# Consultee Comment for planning application 22/01682/F

| <b>Location</b>           | <input type="text" value="Land North Of Manor Farm Noke"/>  |
| <b>Proposal</b>           | <input type="text" value="Development of a ground mounted solar farm incorporating the installation of solar PV panels, associated infrastructure and access, as well as landscape planting and designated ecological enhancement areas."/>   |
| <b>Organisation</b>       | <input type="text" value="CDC - Land Drainage"/>  |

Title:
PV Module Elevation
and Cross Section

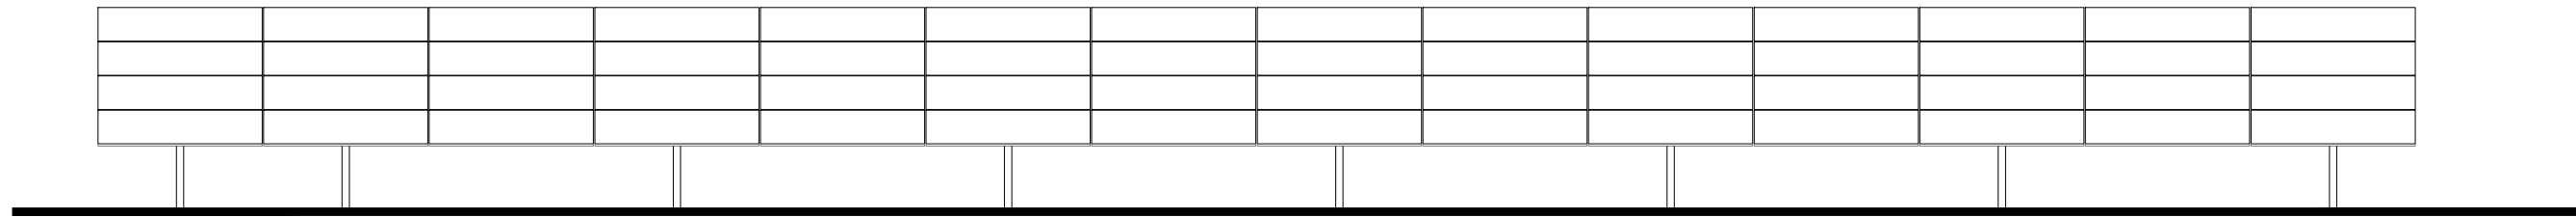
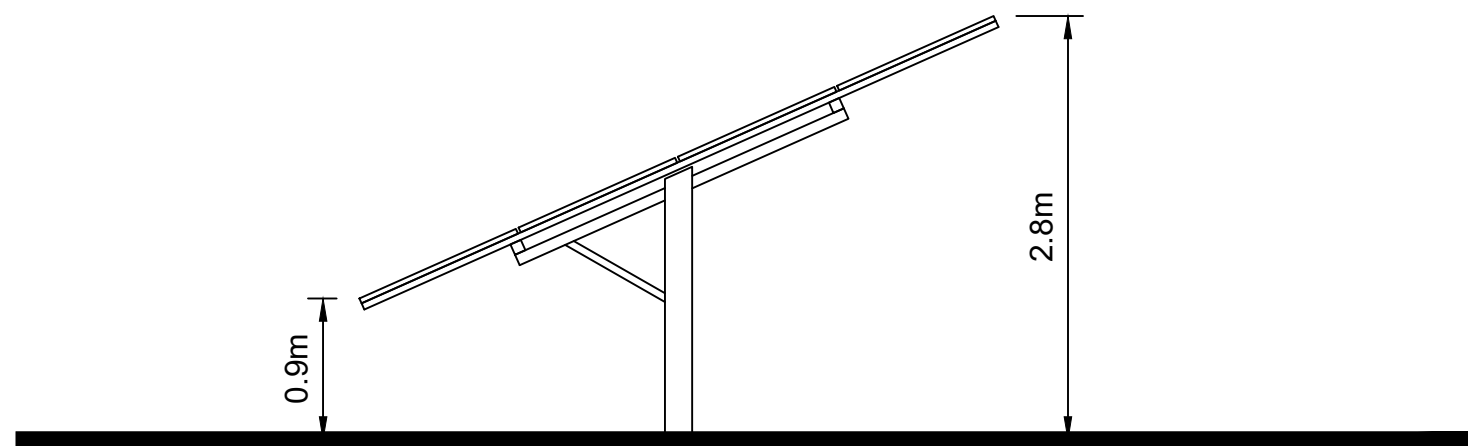
| <b>Comments</b>           | <p>Drainage/Flood Risk</p> <p>The application contains a Flood Risk Assessment within which is a Surface Water Management Plan. Part of the site lies within Flood Zones 2 and 3 though all the photovoltaic cells will be above maximum flood level. Only the supporting posts and some switchgear units will cause flood water displacement to a minor extent. The Surface Water Management Plan contains appropriate attenuation in the form of swales to mitigate the effects.</p> <p>Because it is partly within Flood Zone 3 and if the proposed solar farm is deemed Essential Infrastructure under PPG Table 3 an Exception Test is required. As the proposal is for the carbon-free generation of power I am satisfied that the Exception Test can be passed and that all flood risk considerations will be appropriately managed.</p> |
